From: [Neil McBride](#)
To: [Cottam Solar Project](#)
Subject: Cottam Solar ExAs Questions
Date: 22 November 2023 13:28:57
Attachments: [image003.jpg](#)
[image001.png](#)
[image004.png](#)
[image005.png](#)
[image006.png](#)
[image007.png](#)
[image008.png](#)
[image009.png](#)

Further to the Council's response to the ExAs first round of questions – in respect of Q1.12.26 further details are provided below

9.4: Claimed routes

Sheet by sheet review

Land Plans
Sheet 11 of 19
Revision B

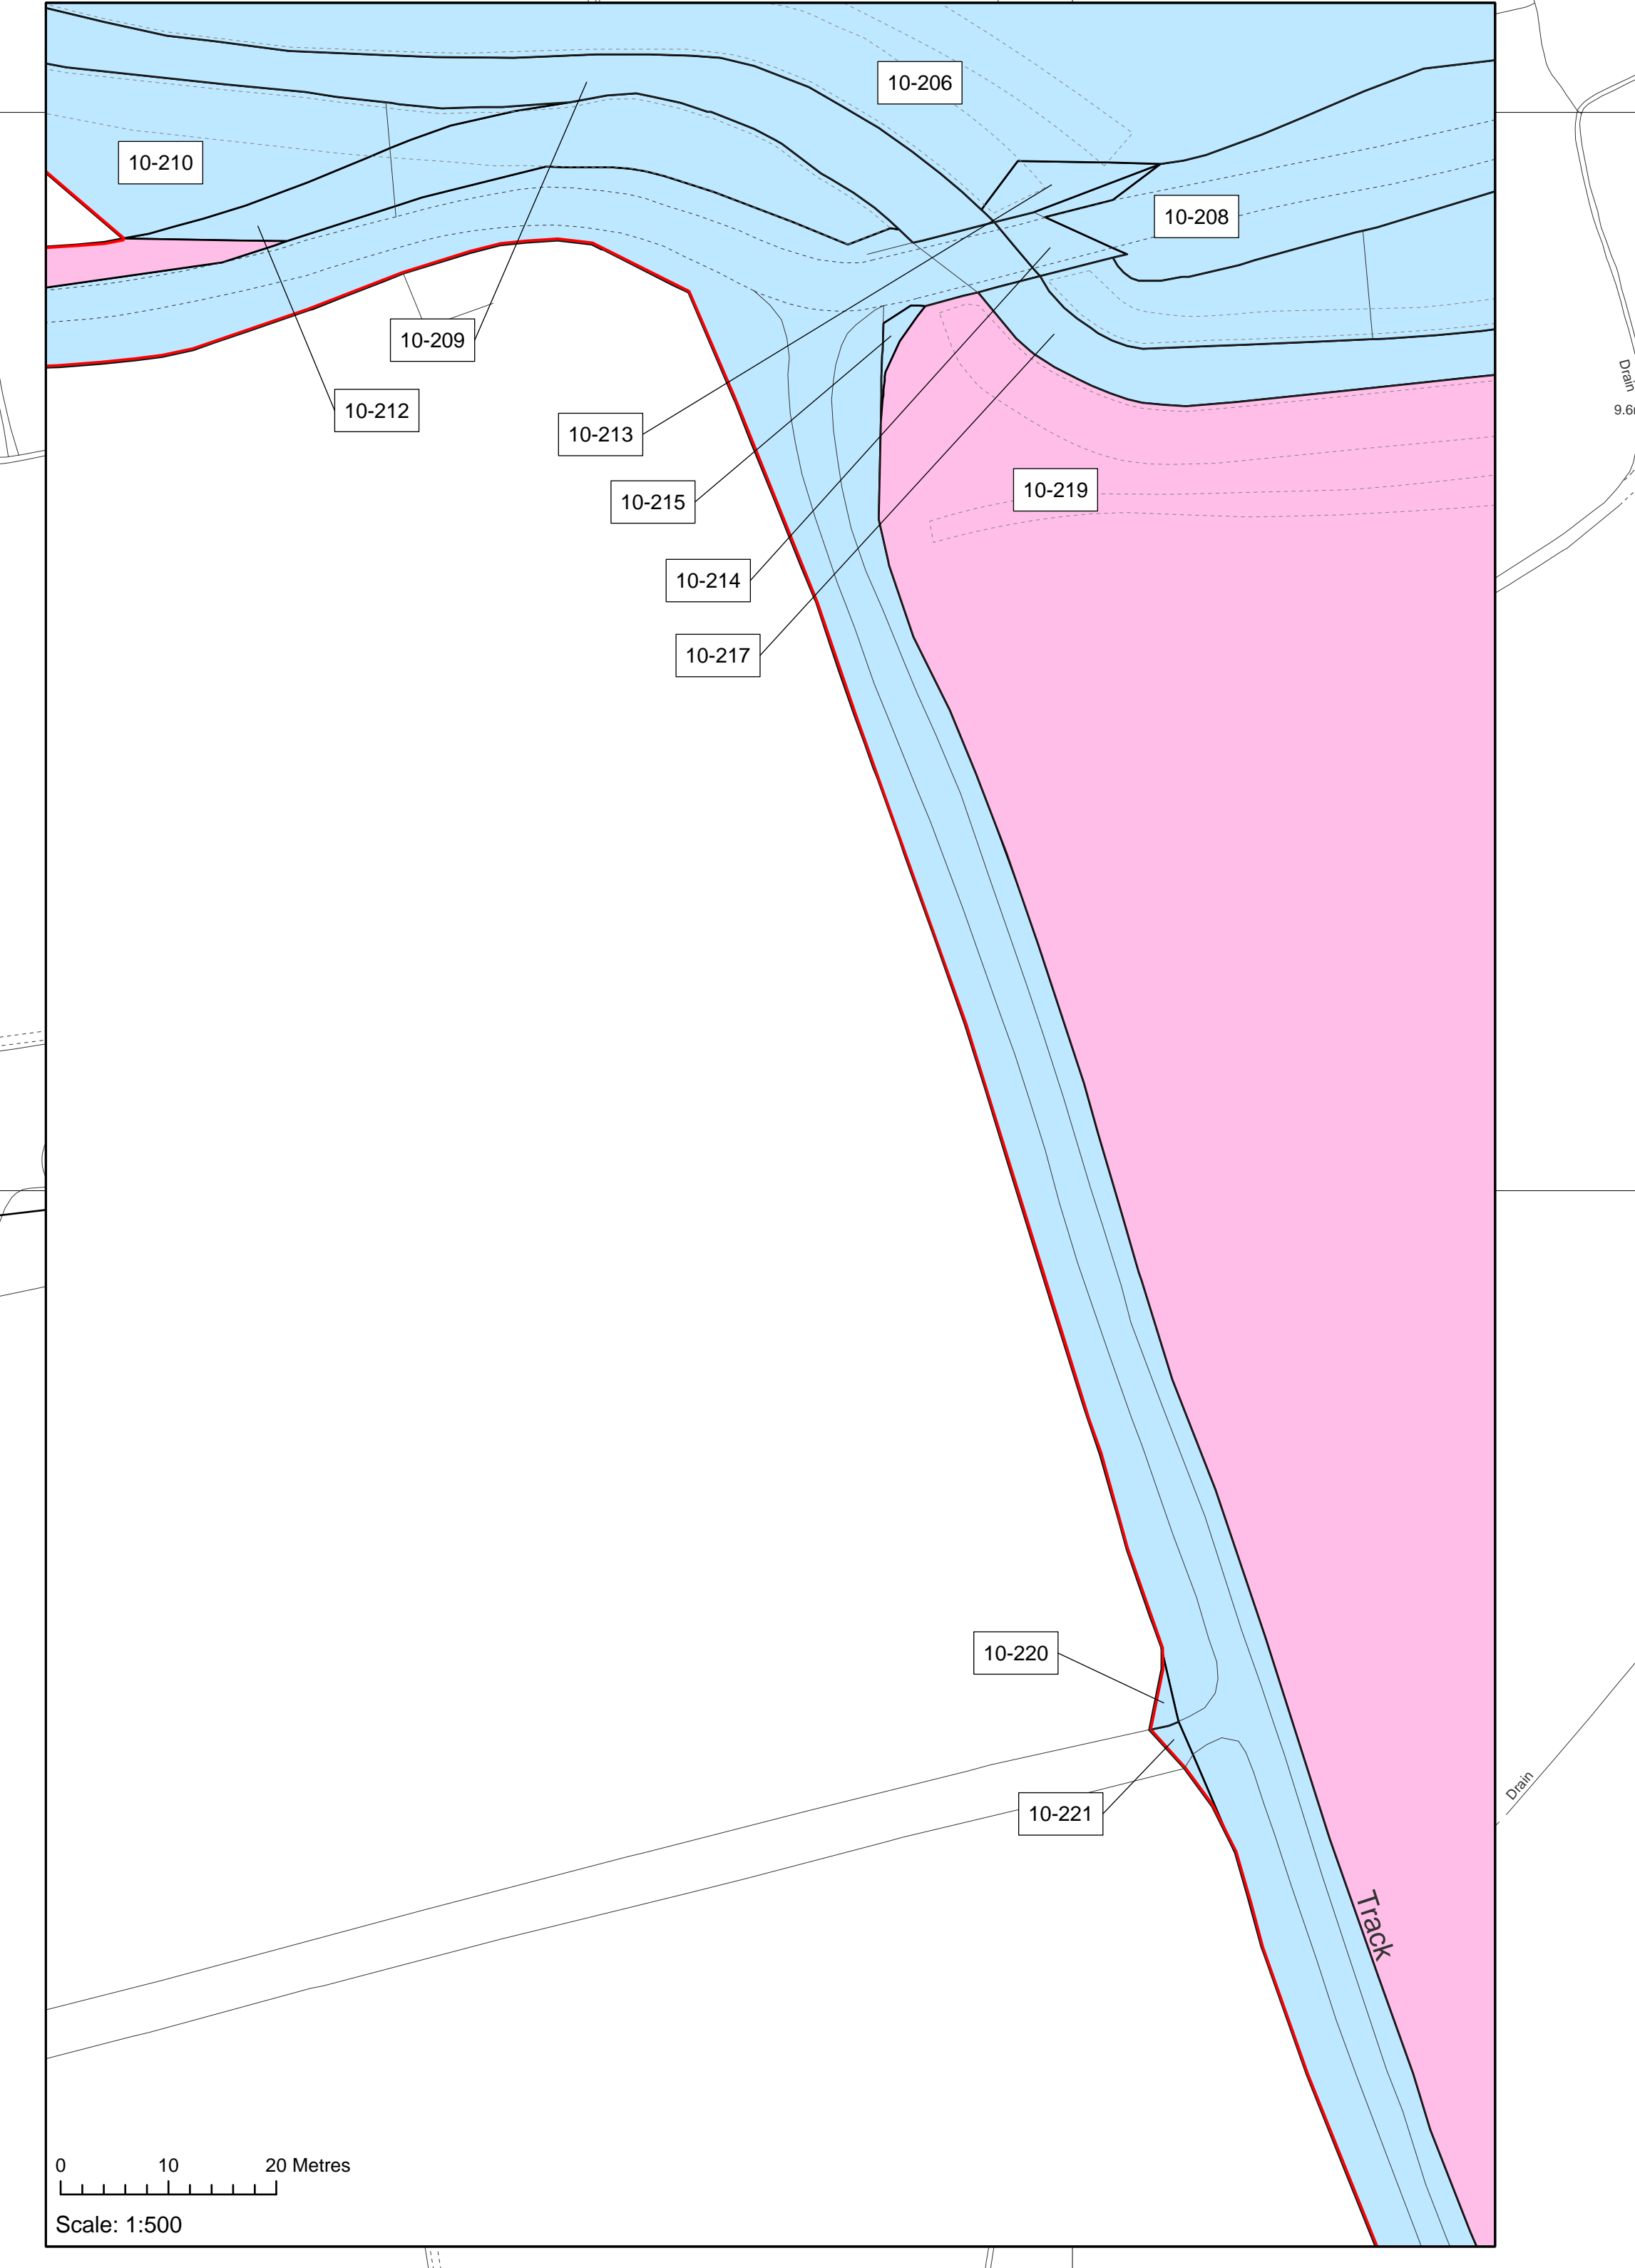
Sheets 11:

FP 83 - The proposal does not widen the route like Pilh/20 - is this sufficiently wide already to allow PROW users and traffic to pass? There is an extremely large diversion area included in the rights of way plan Sheet 9 - any deviation into that area would significantly negatively impact the utility of the route. The direct line should be preserved.

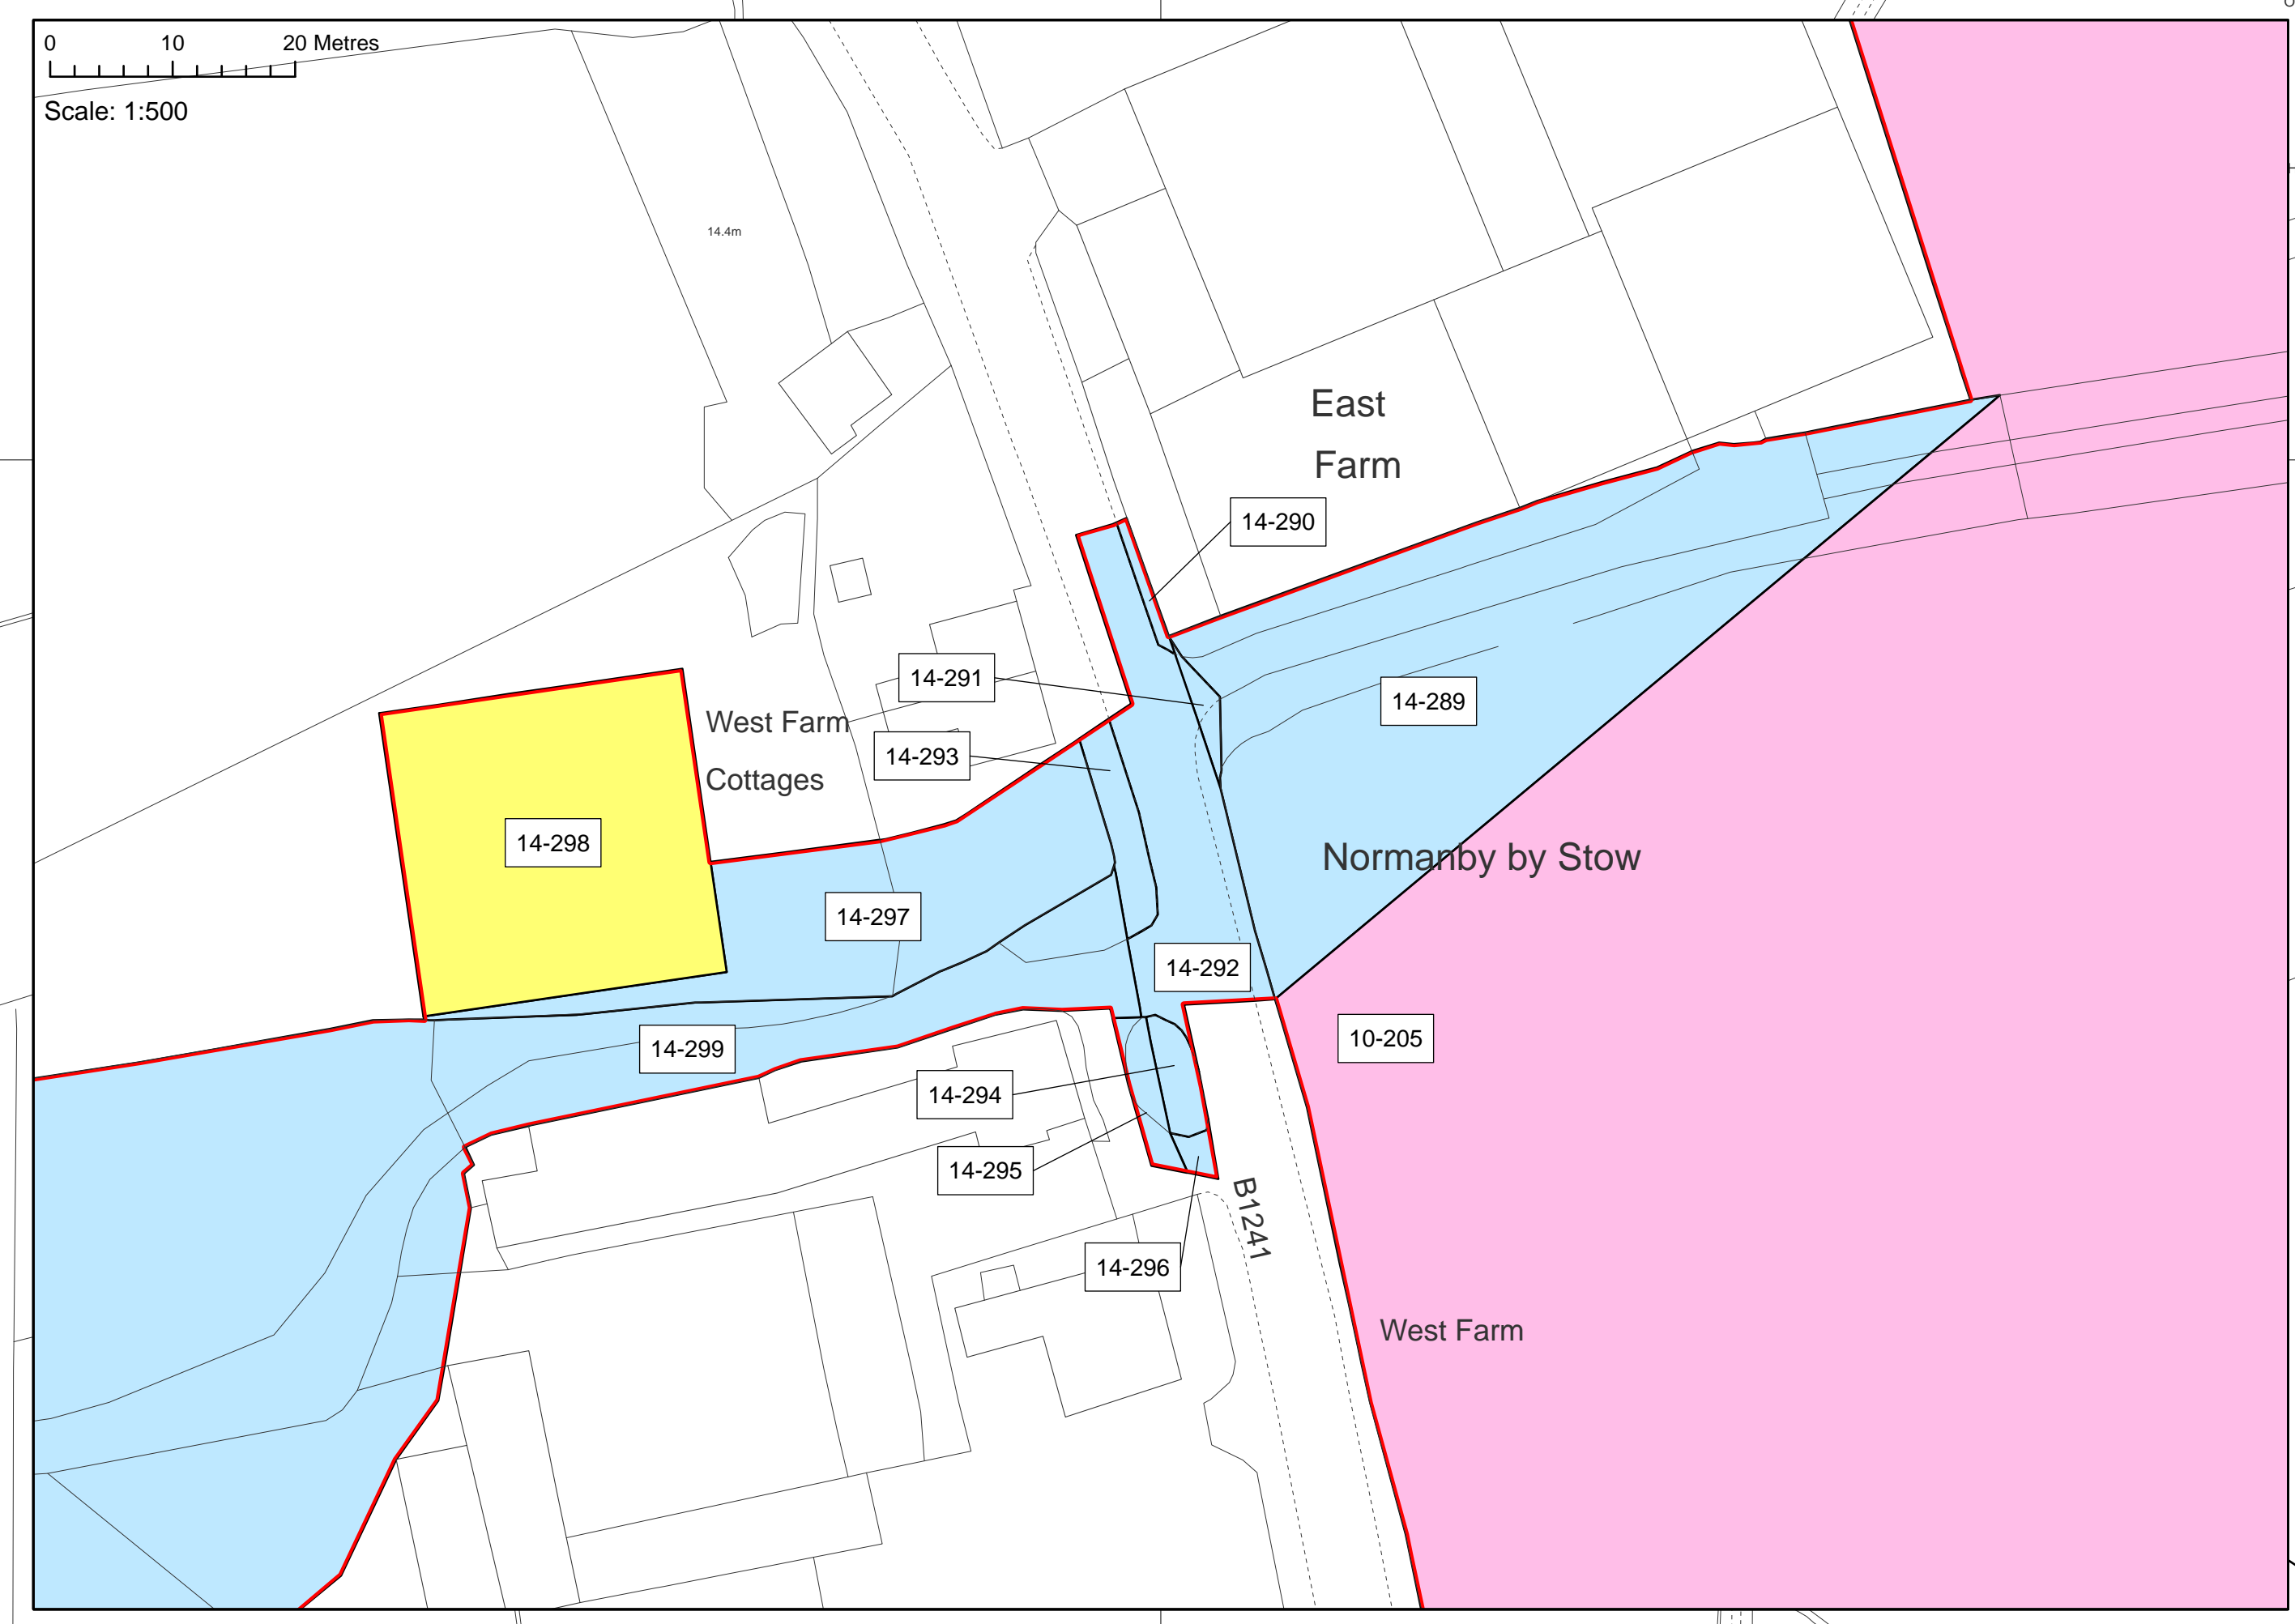
Sheets 13:

TFLe/31 impacted.

Extremely large diversion area included in the rights of way plan Sheet 11 - From a recreational point of view for users, horse riders in particular, there is a potential for a circular bridleway route to be included around this area as an enhancement to the scheme in this area instead of just a linear diversion.
